# CITY OF ALBUQUERQUE

RE: **Lot 29 Block 8 Unit 22 Volcano Cliffs SAD 228**  
**6401 Picardia NW**  
**Grading and Drainage Plan**  
**Engineers Stamp Date 1/19/17 (D10D003E29)**

**From:** Rael, Rudy E. [mailto:RRael@cabq.gov]  
**Sent:** Thursday, January 19, 2017 9:24 AM  
**To:** 'David Soule (david@riograndeengineering.com)'  
**Subject:** 6401 Picardia

ENGINEER'S SEAL  1/16/17 DAVID SOULE P.E. #14522	LOT 29, BLOCK 8, UNIT 22 VOLCANO CLIFFS	DRAWN BY JDG
	GRADING AND DRAINAGE PLAN	DATE 01-15-2017
 1606 CENTRAL AVENUE SE SUITE 201 ALBUQUERQUE, NM 87106 (505) 872-0999		SHEET # 1 OF 1
		JOB #

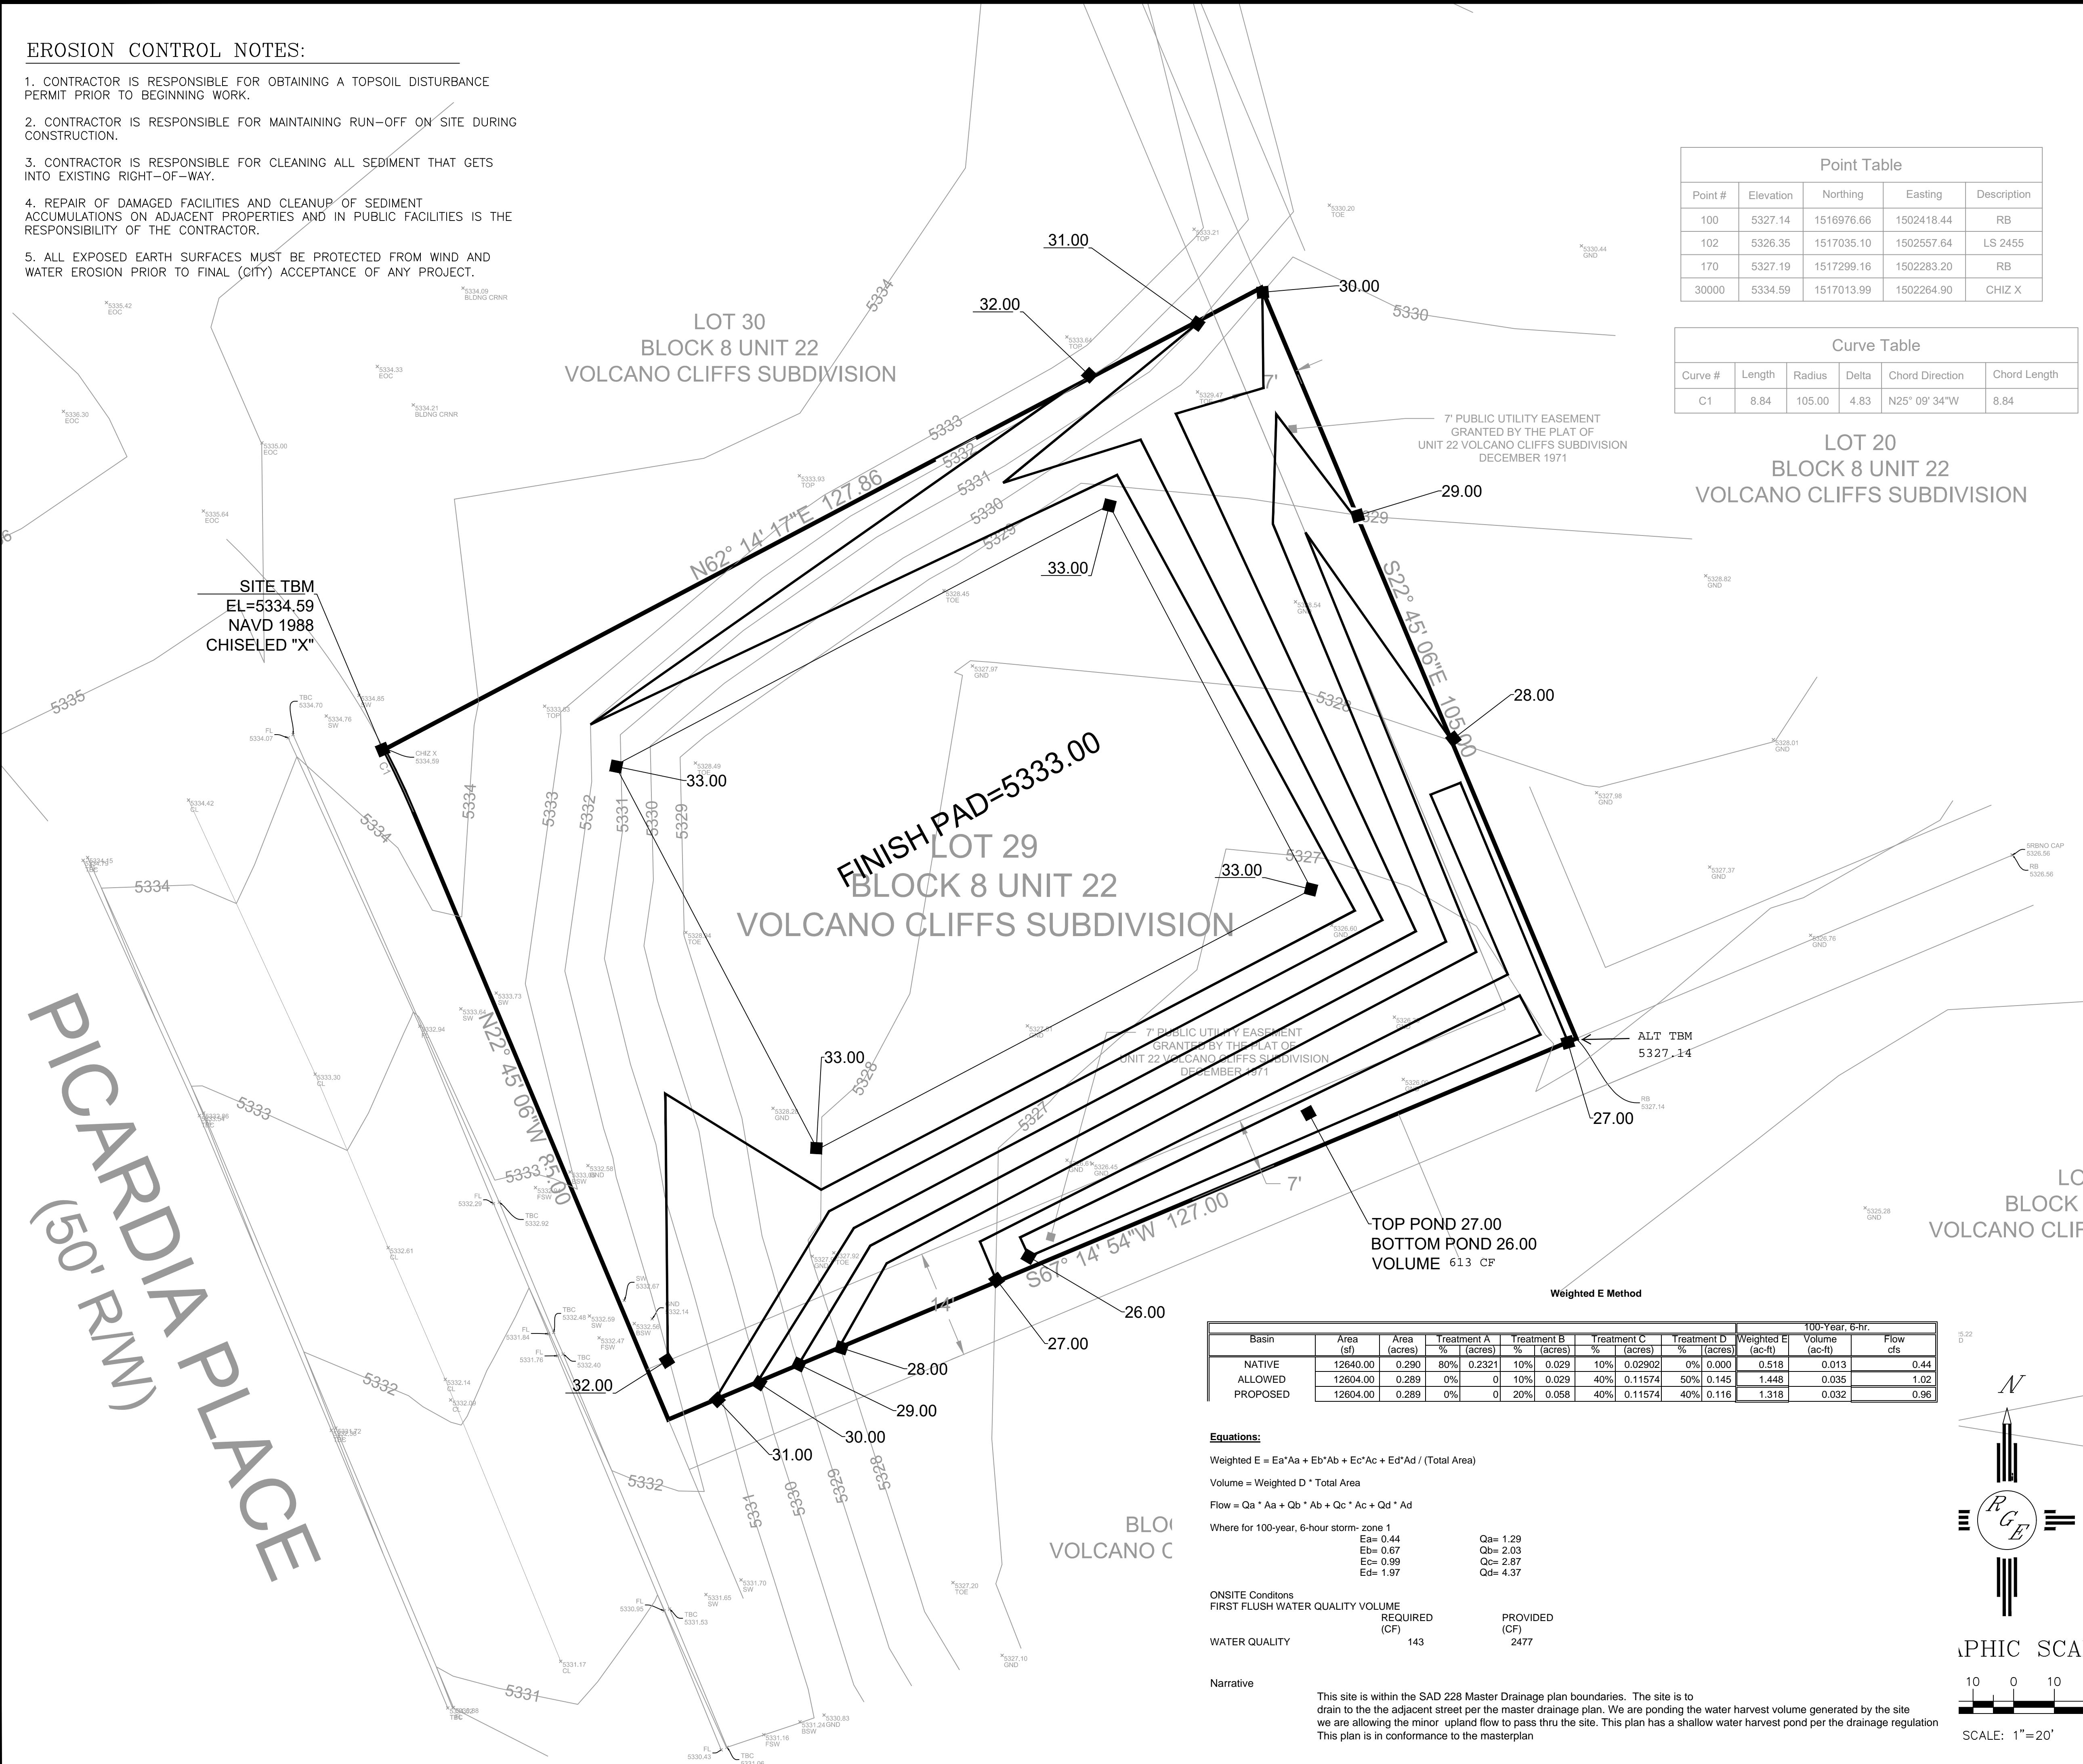
Based upon the information provided in your submittal received 1/17/17, the above referenced Grading and Drainage plan dated 1/16/17

cannot be approved for Grading Permit until the following comments are addressed:

- Provide a note stating that future garden walls require a separate permit and this plan should be used for their placement. [We have added note](#)
- Also state that future garden walls require an opening 3" above grade in the NW corner and SW corner. [We have added note](#)
- Provide a note stating retaining walls are not allowed in the rear yard unless a swale is provided so flows may pass from the property to the north into their property and to the south property. [We have added note](#)
- Provide a statement that a pad certification is required before a building permit is given. [We have added note](#)
